10th Feb. 2020

Application No: EP/160/19/PL - Land To Rear of 43 Sea Road,
East Preston - Construct a single storey extension to create a
2 Bedroom Apartment

SITE PLAN 1:500 @ A4

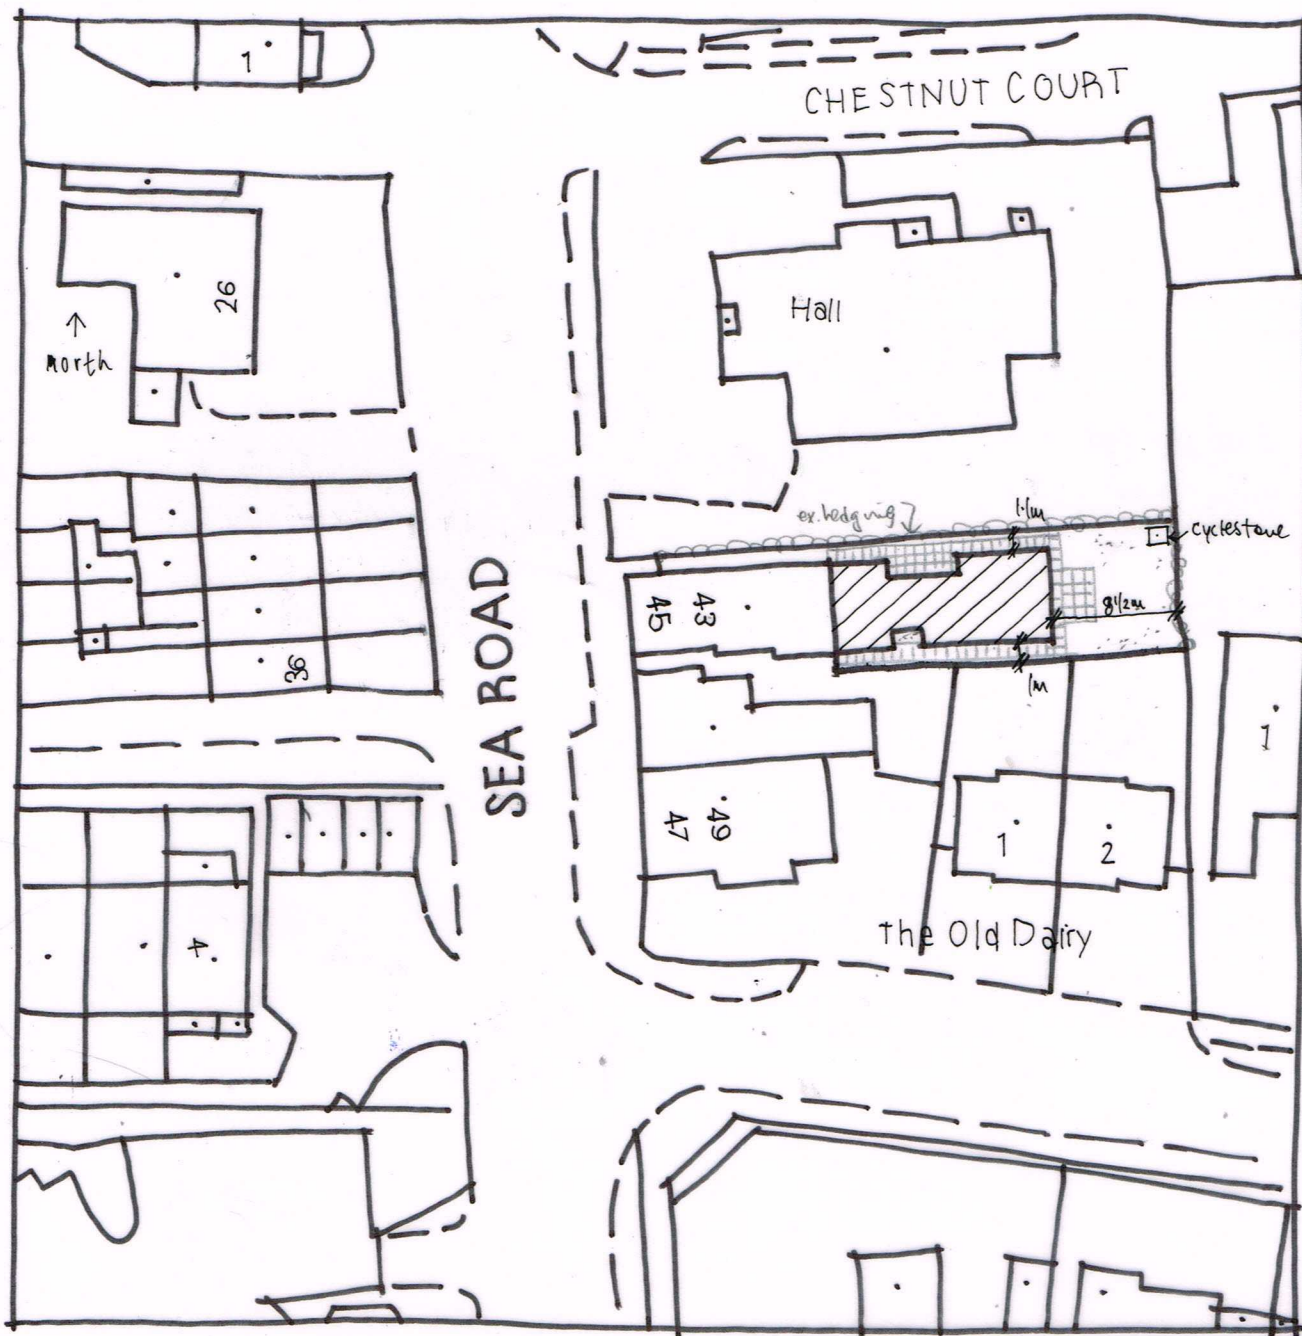
- premises shown for site as ⁴³45 : Should be 43.
- adjacent next door is blank : Should be 45
